City of Albuquerque

November 30, 1982

Re: Industrial Electric Equipment Service Addition - Dated 11/12/82
501 Kinley Avenue SE (File No. J14-D9)

DRAINAGE PLAN - SHEET 1 of 1
REPAIR SHOP ADDITION-INDUSTRIAL ELECTRIC
501 KINLEY AVE., NE DALLAS 6-586

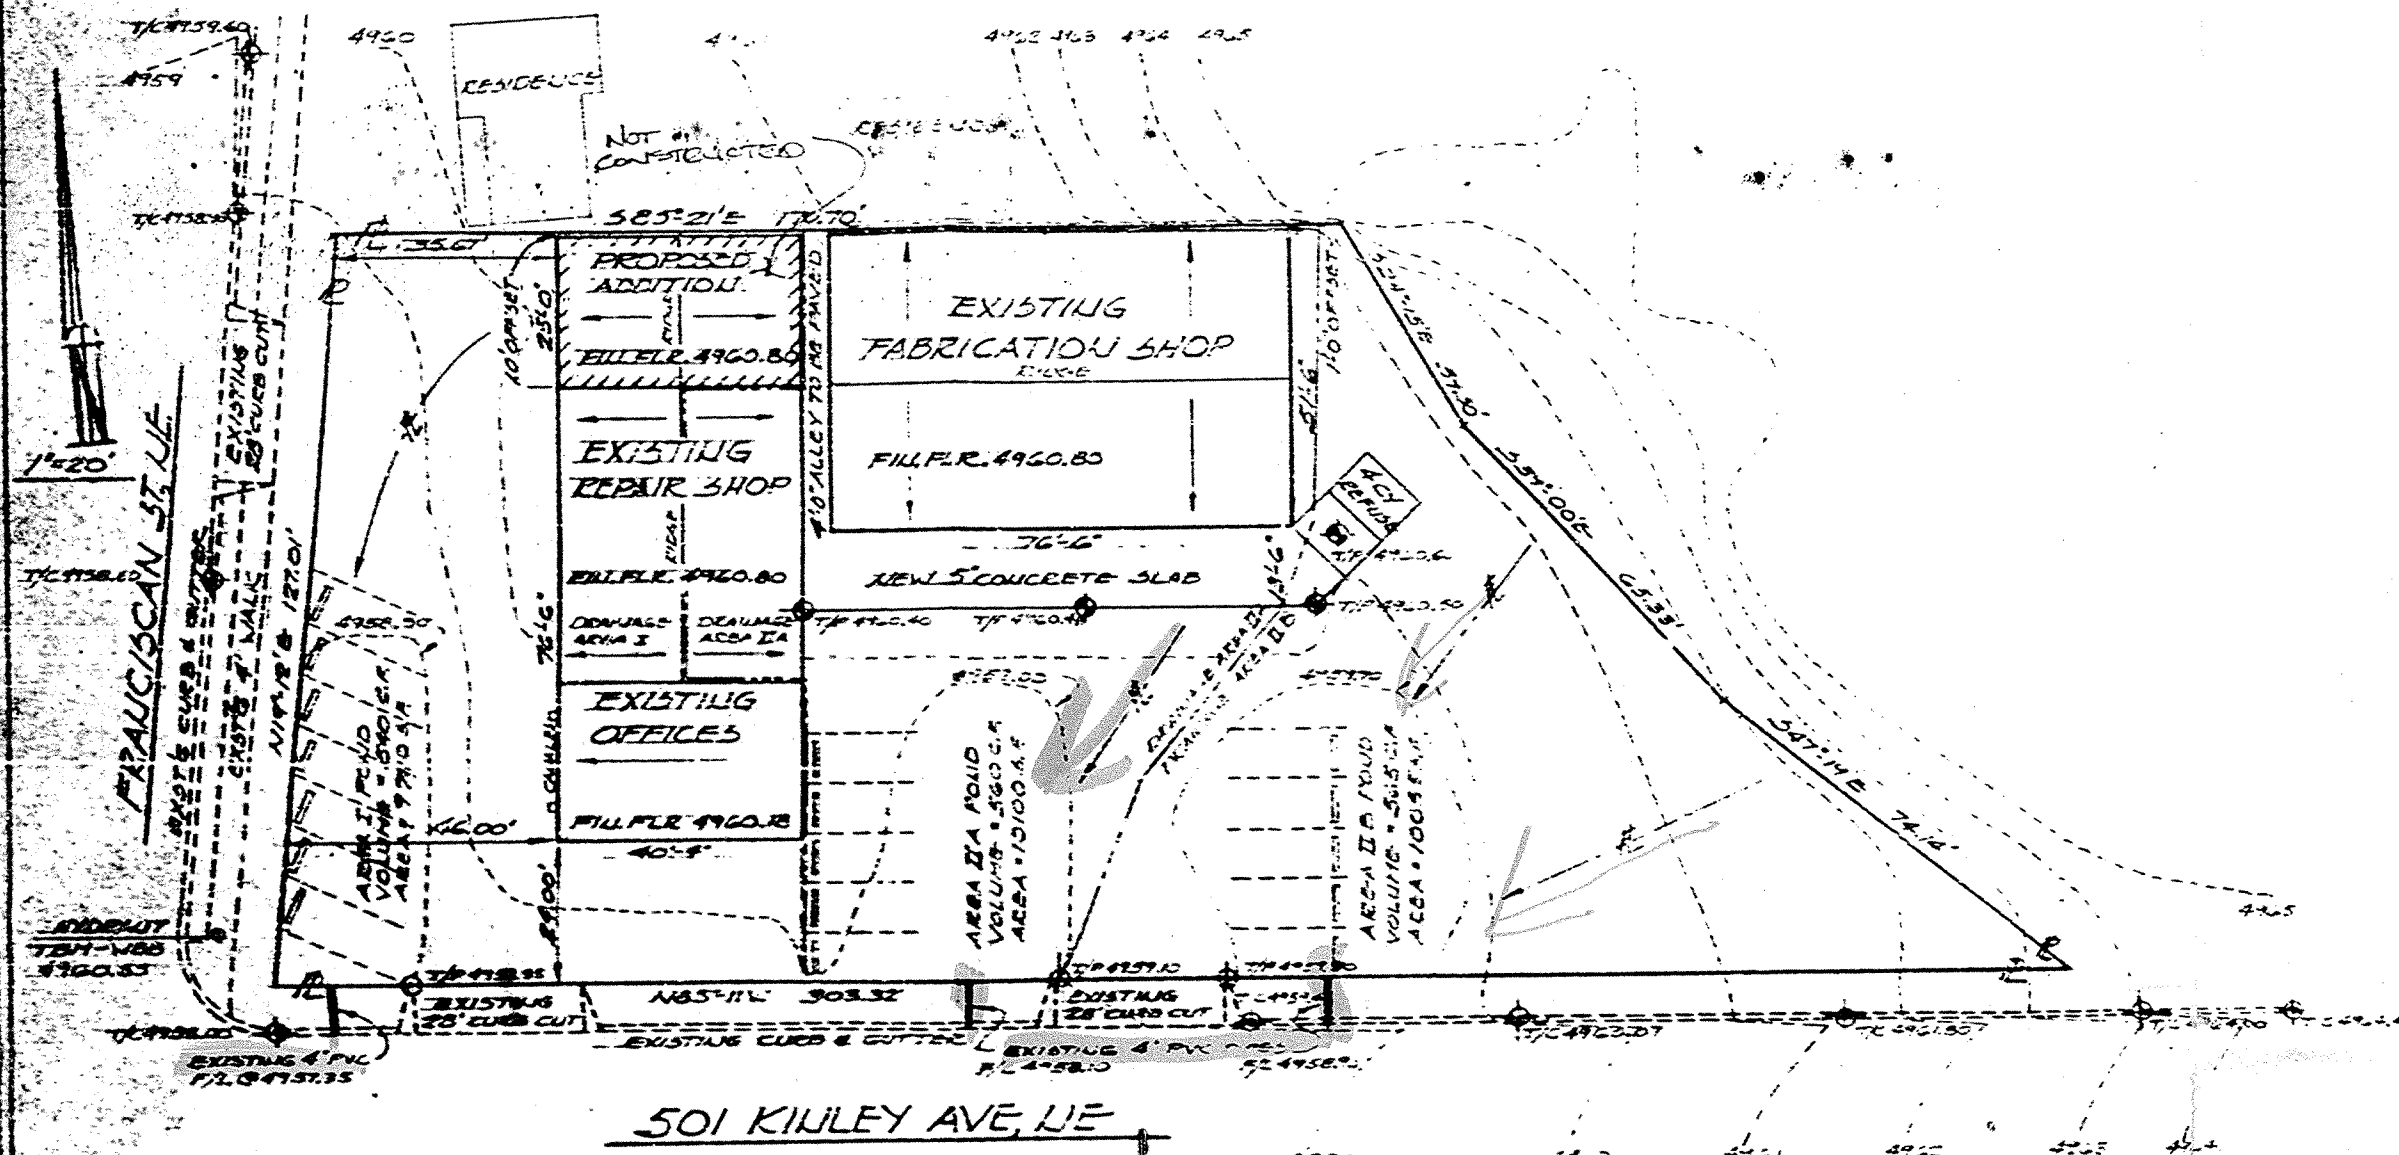
The proposed addition for the referenced site does not address how the 4 foot change in grade along the north property line will be accomplished to maintain the integrity of the existing grade on the abutting property to the north. Also, please provide us with a typical detail or details of the proposed swale along the west side of the proposed addition.
